PLANNING DEPARTMENT – Development Review Services

August 28, 2015

**RE: South Los Altos Children's Park  
Grading & Drainage Plans  
Engineer's Stamp Date 8-04-2015 (File: K20D062)**

SOUTH LOS ALTOS CHILDREN'S PARK
GRADING AND DRAINAGE PLAN - SOUTH

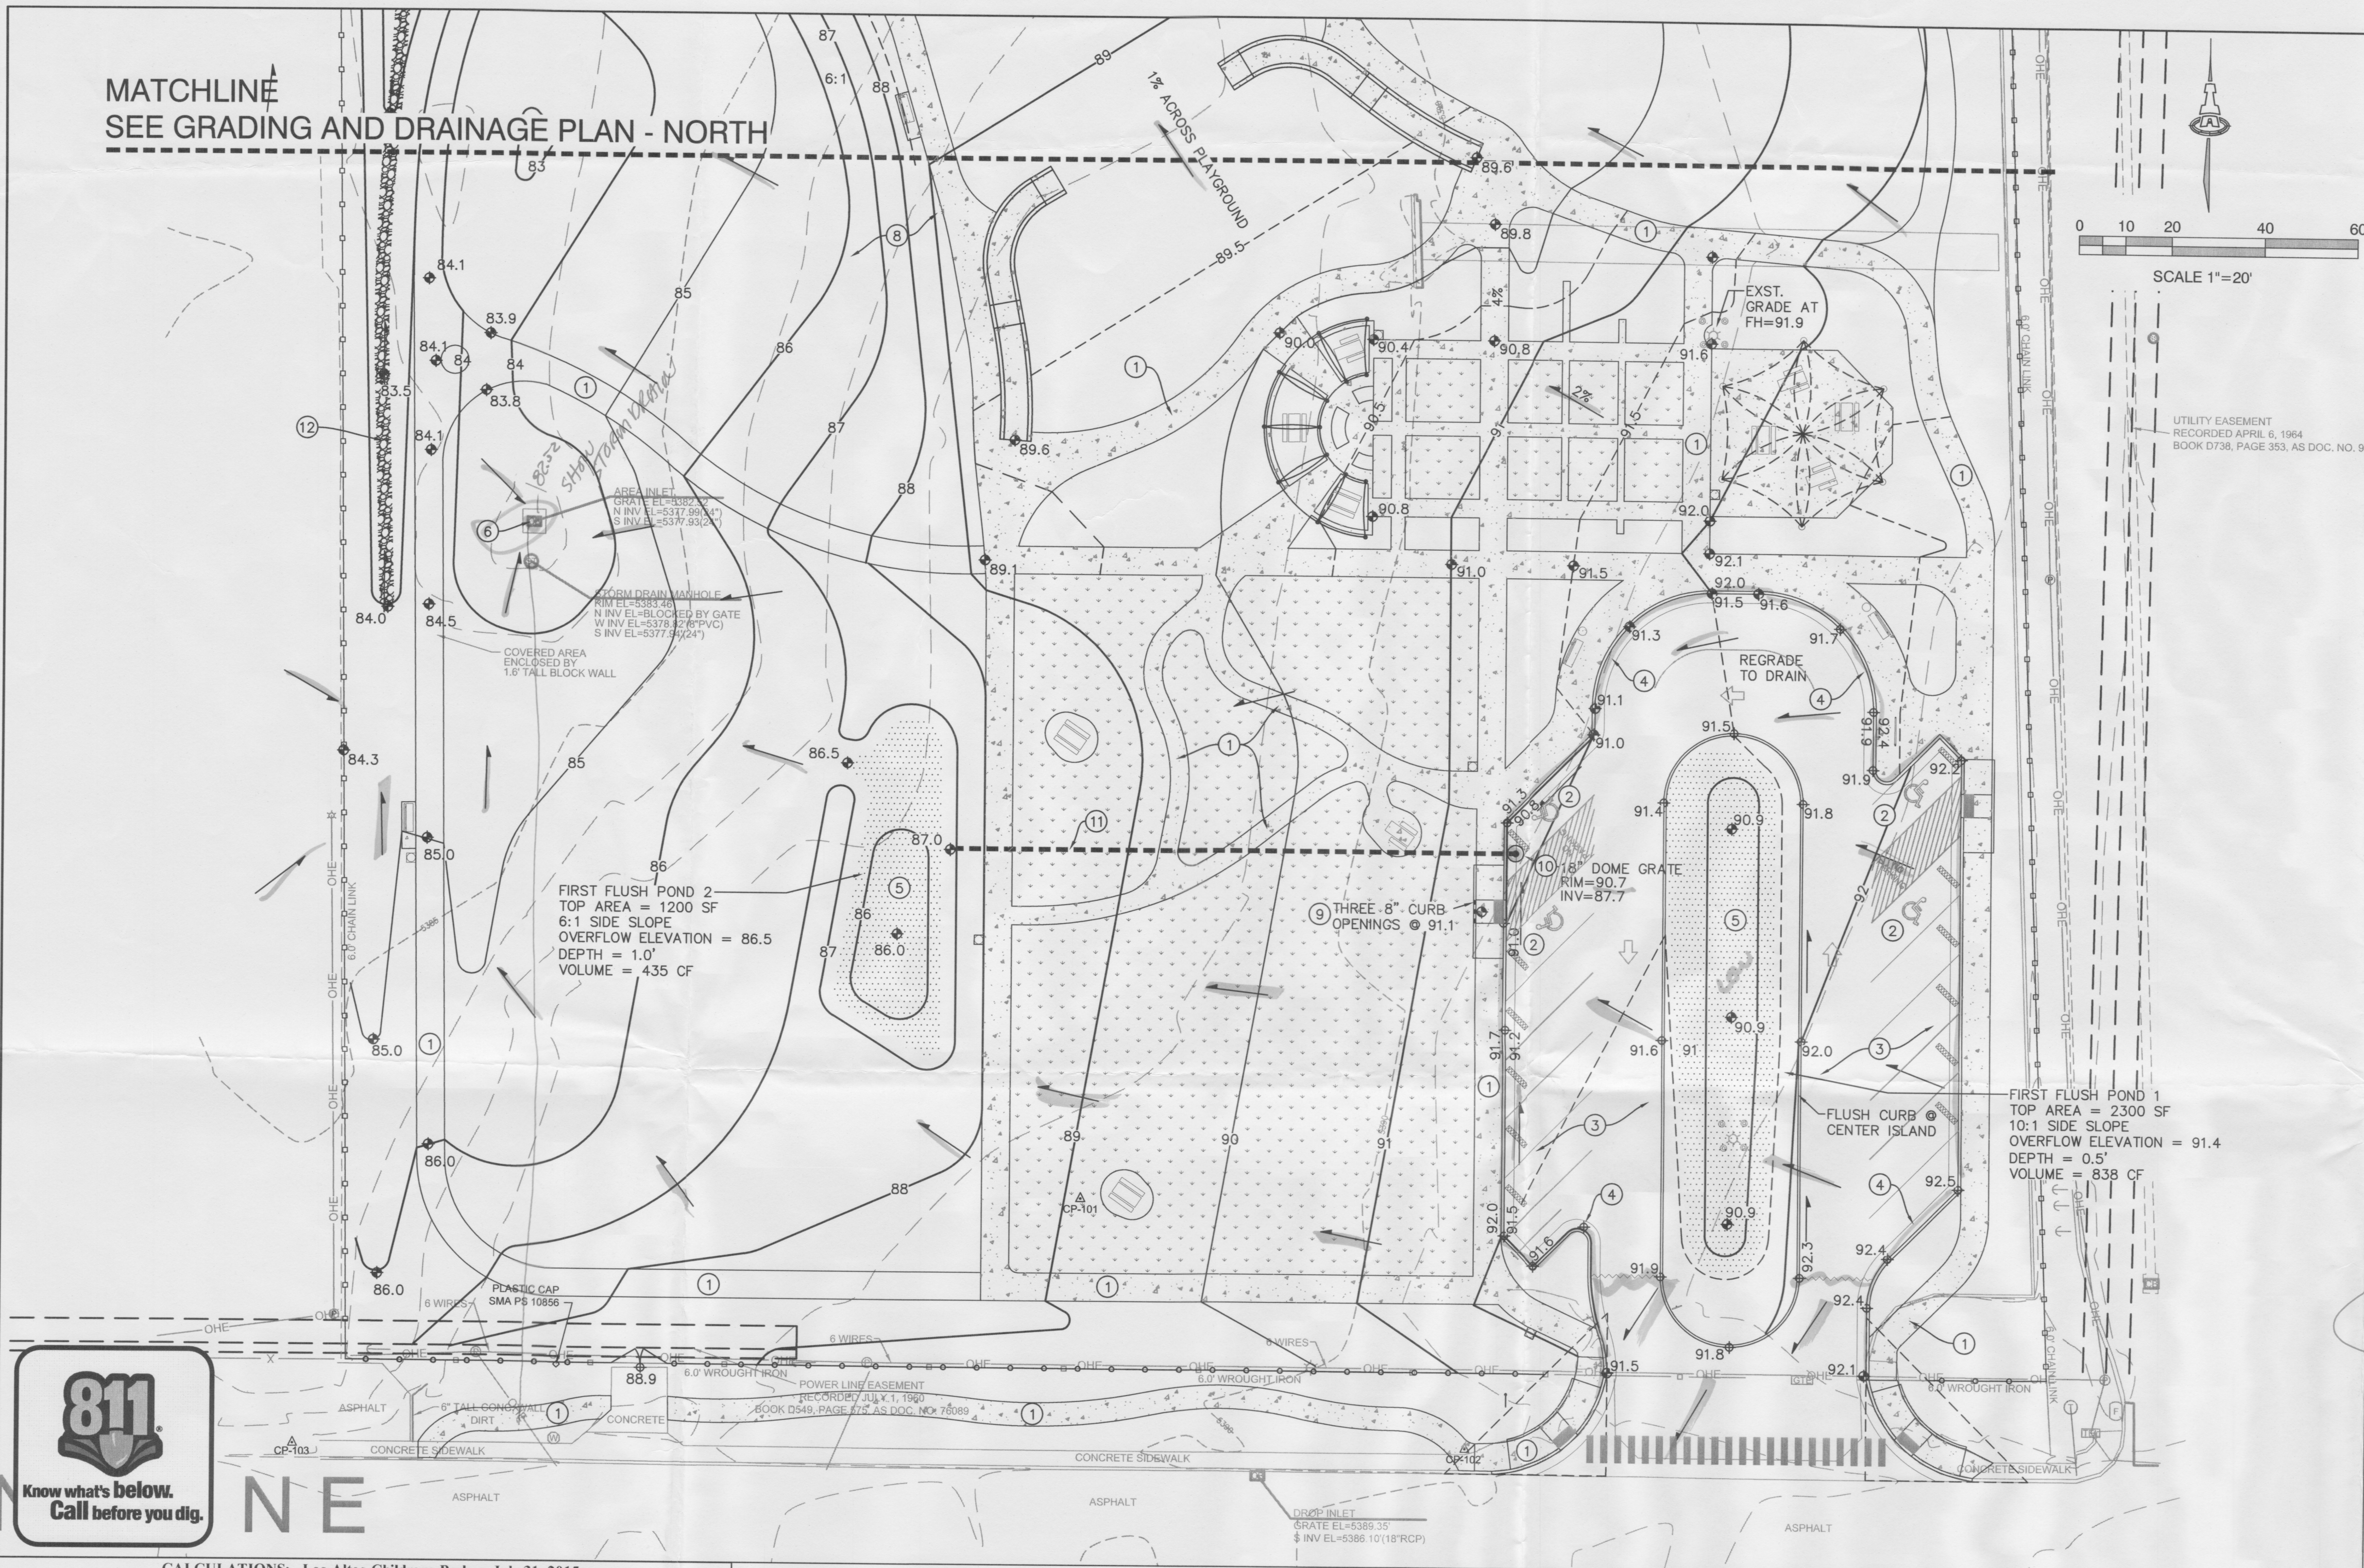
The platting action associated with this site will require a cross-lot drainage easement to accept offsite flows from the west and north. It is noted that flows from the east do not enter this site.

Prior to Grading Permit approval, show the existing storm drain system on the plan.
